CITY OF ALBUQUERQUE
PLANNING DEPARTMENT
DEVELOPMENT REVIEW BOARD

Project# 1007081

11DRB-70180 VACATION OF PUBLIC RIGHT-OF-WAY

DAC ENTERPRISES, INC agent(s) for PULLMAN INVESTMENTS LLC request(s) the referenced/ above action(s) for all or a portion of **WILLIS PLACE SW** adjacent to Tract C, **SHELL SUBDIVISION NUMBER ONE** located on WILLIS PL SW east of RIO GRANDE BLVD SW (south of CENTRAL AVE SW). (J-13)

**PURPOSE OF PLAT:**

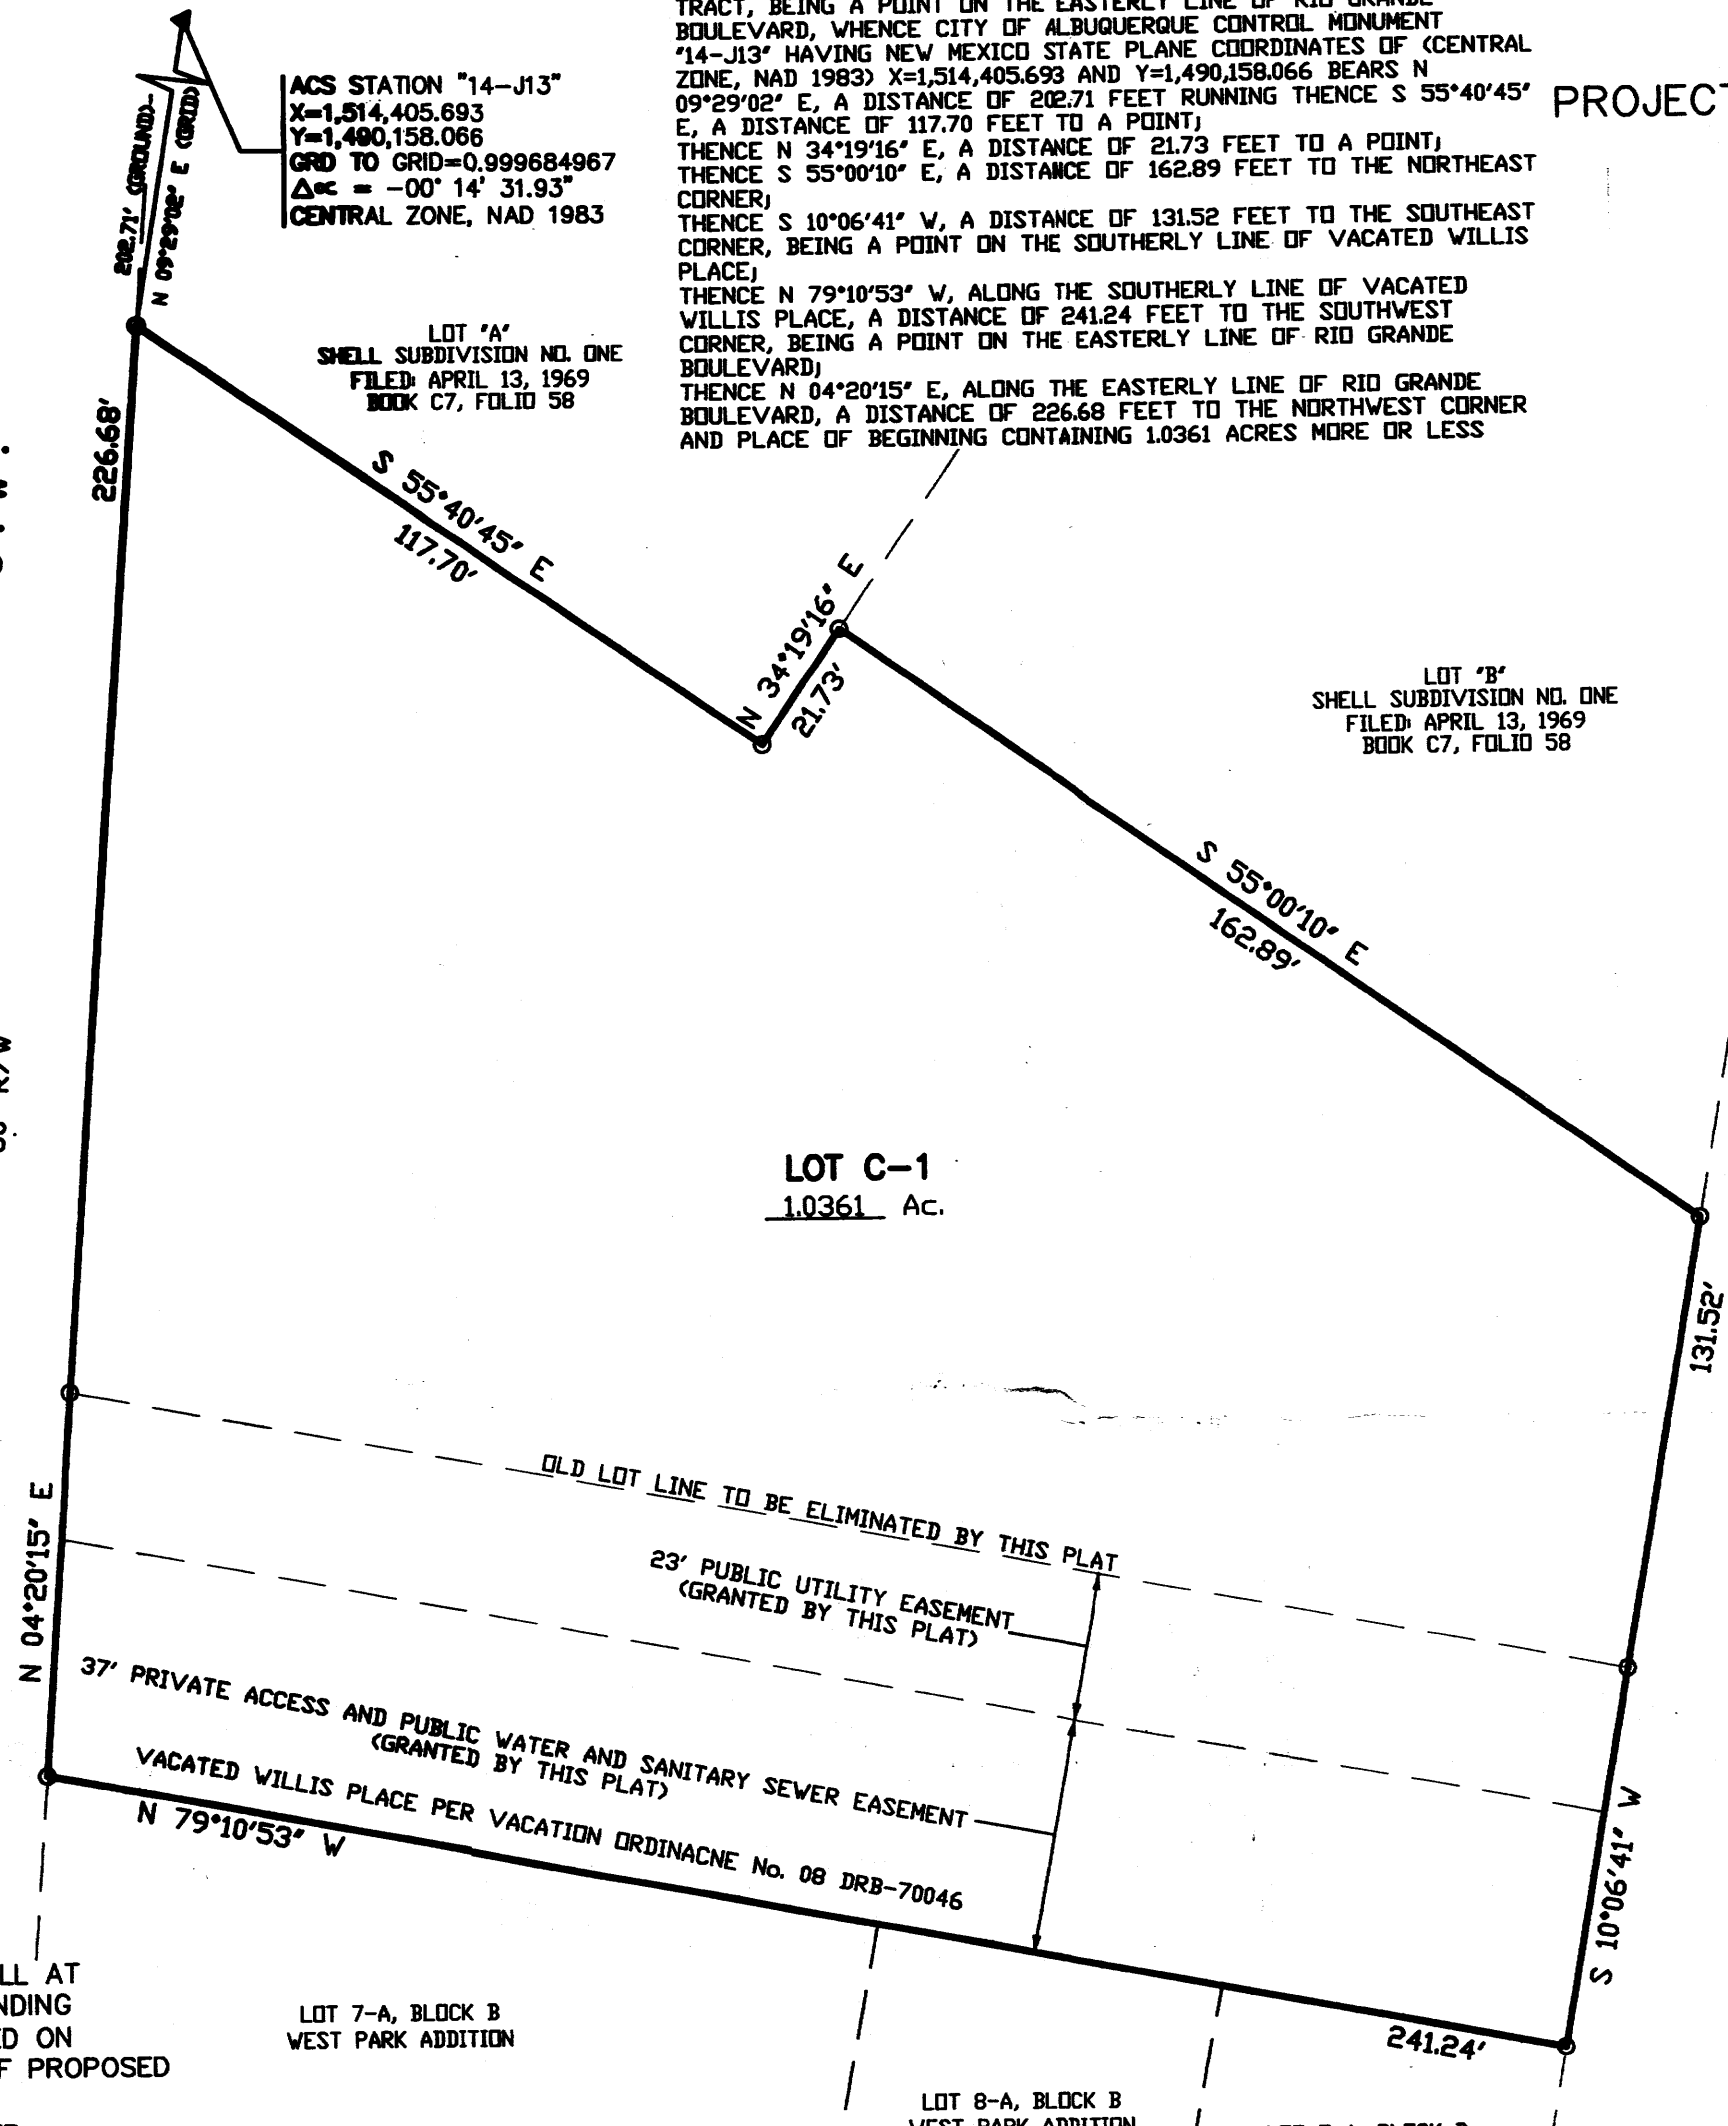
Sheet 2 needs to reference Vacation **Application** (not Ordinance) No. 11DRB-70180.
